**St John of God Richmond Hospital
Redevelopment
SSD-10394**

Response to request for information

On behalf of St John of God Health Care

February 2022

Figure 3: North elevation of pavilion 4

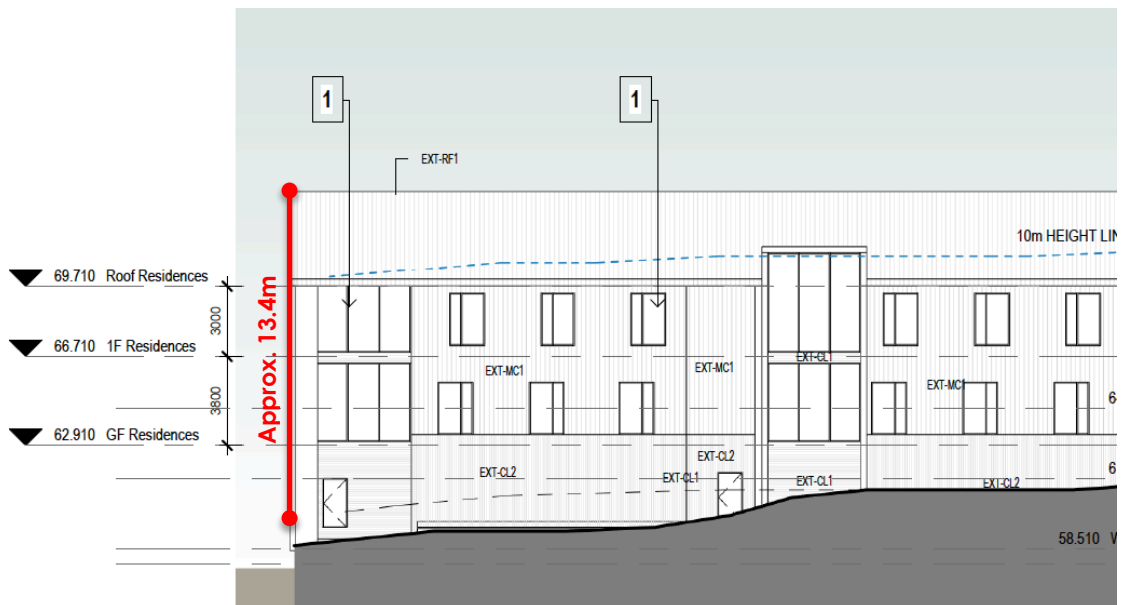
Table 1.4 Response to DPIE	
Building height and Clause 4.6 variation	
Issue	Response
Provide the existing ground level used to calculate maximum building height and Clause 4.6 variation and identify these points on relevant drawings showing the 10m height limit – it currently appears that the 10m height limit of Pavilion 4 aligns with the roof residence height at RL69.710, which results in an exceedance of 4.06m (overall building height of RL73.77 minus RL69.710) rather than 3.4m.	The measurement has since been updated as the breach culminates in a maximum of approximately 2.117m (or 21%) at the very southern end of pavilion 4 where the existing land slopes. This has come about as a result of residential pavilion 4 being rotated to align with the Bushfire Report noting that the building will be situated no closer than existing buildings to the flame zone. Important to note that the buildings have not been altered in height and not pose any additional amenity impacts. Refer to Appendix A Part 2b - Clause 4.6 Variation_Updated Report - Figure 3: East elevation pavilion 4 which clearly articulates levels.

Drawing Number: SSK10

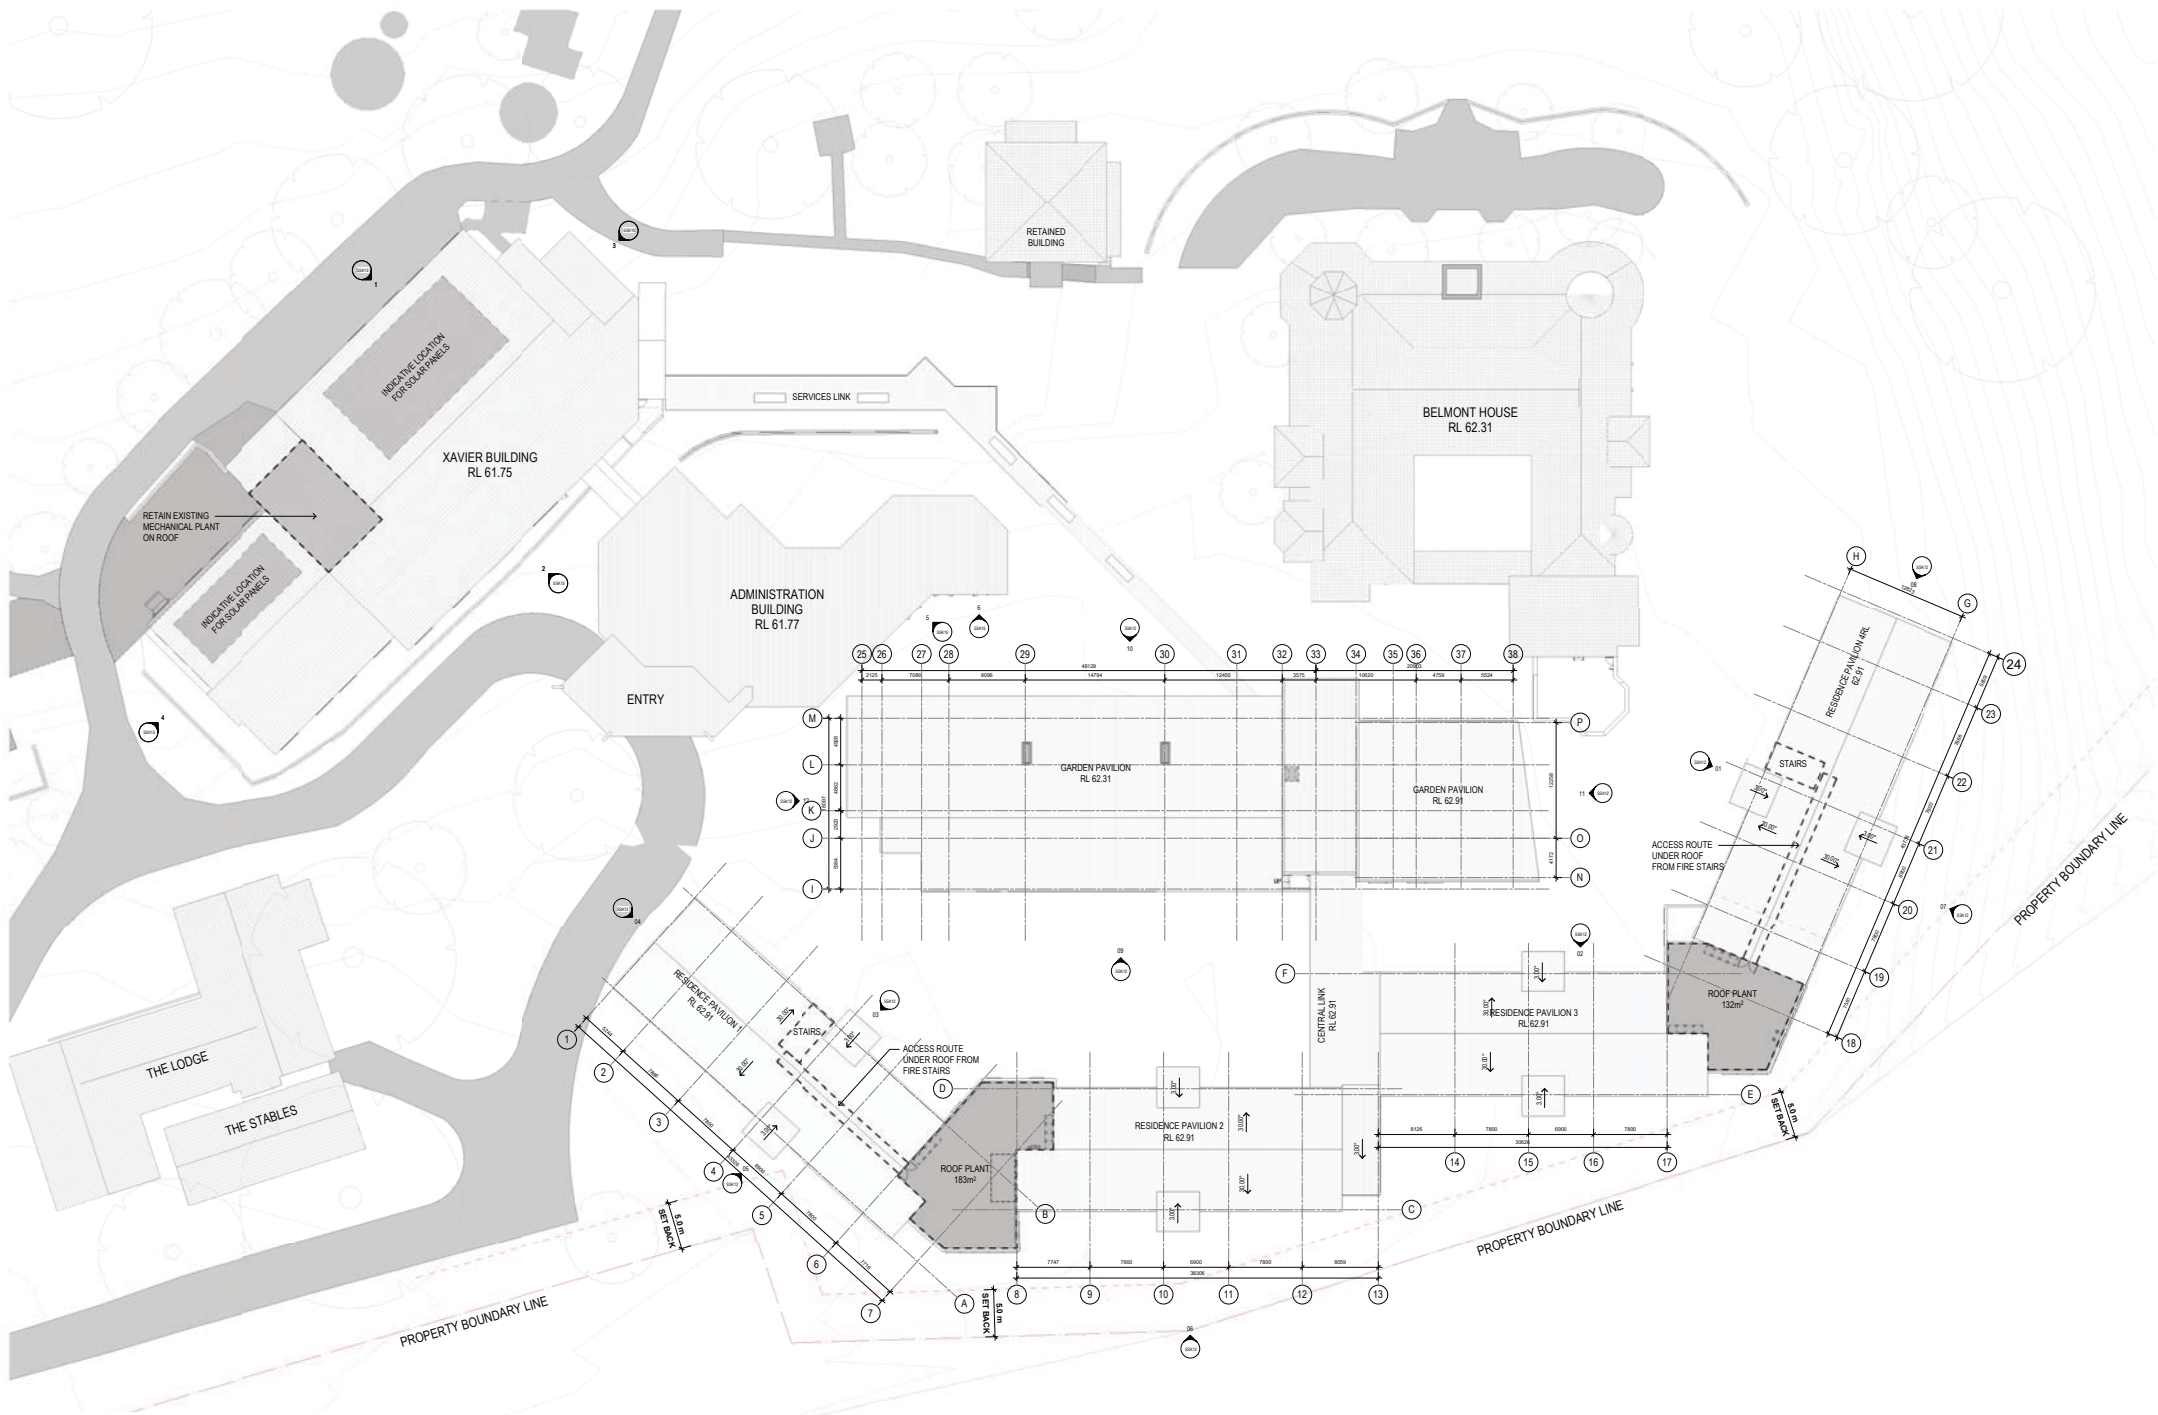
The lounge and kitchen areas in the residential pavilions are no longer shown on the plans. It is unclear why?

Printing error, drawings to be reprinted. Refer to **Appendix A Part 1d, updated on drawings SSK09 & SSK10** for notes delineating areas of lounge & kitchen.
